Re: Land to the East of Shripney Road, Shripney, Bognor Regis

We have today submitted via the Planning Portal a Non-Material Amendment (NMA) to Reserved Matters condition 1 (Ref: BE/61/23/RES) pursuant to Outline Planning Permission (Ref: BE/109/19/OUT), under reference **PP-14602550**.

Detailed Planting Plan 1 of 3

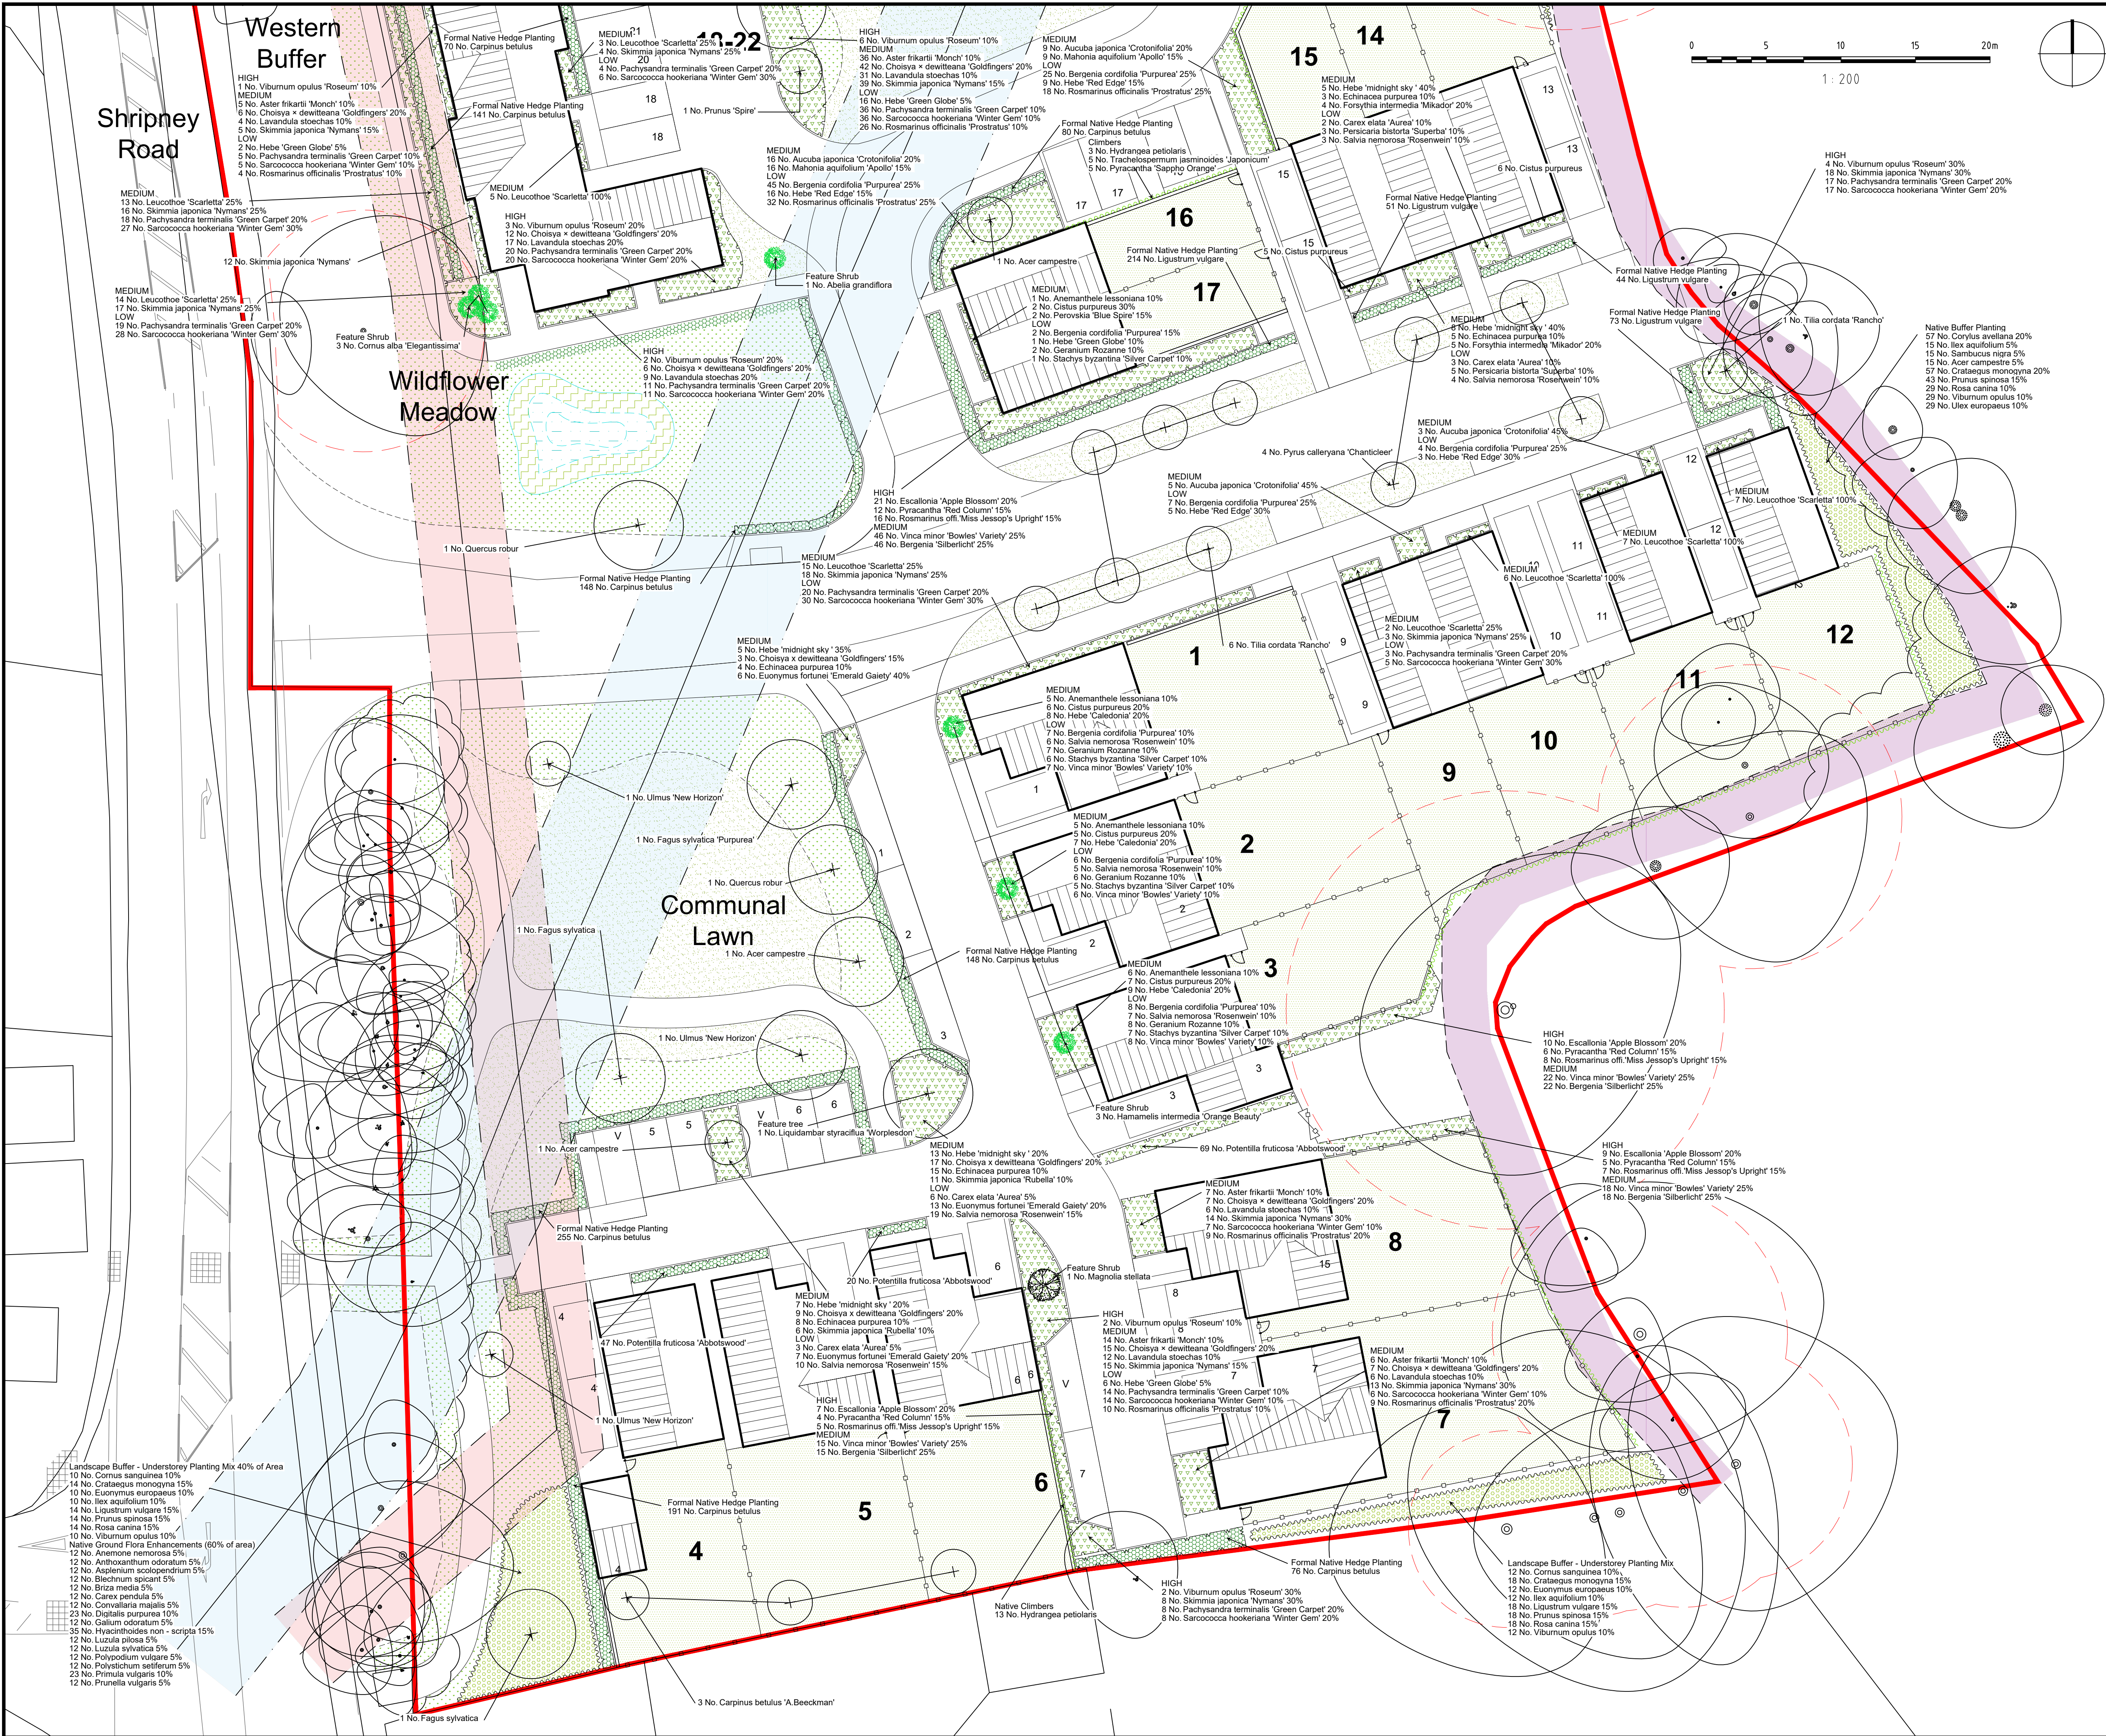
The proposed amendment relates to changing the specification of grass to the rear gardens of properties from **'Proposed lawn to back gardens – Naturescape N14 Flowering Lawn Mixture or similar' (as approved)** to **'Proposed amenity lawn to back gardens using high quality turf - Rowlan Medallion or similar' (as proposed)**.

This proposed change is at the request of Aster Homes (Housing Association), with whom we are currently in contract for the sale of all 44 plots on the site. A flowering lawn mixture in rear gardens creates maintenance issues for the homeowners, and hence a more typical turfed amenity lawn is preferred.

- 602-01 Rev H Engineering Details Drainage Layout (UNCHANGED)
- DD598L01 Rev D Illustrative Landscape Strategy Plan (UNCHANGED)
- DD598L03 Rev C Detailed Planting Plan 1 of 3 (REVISED)
- DD598L04 Rev C Detailed Planting Plan 2 of 3 (REVISED)
- DD598L05 Detailed Planting Plan 3 of 3 (UNCHANGED)
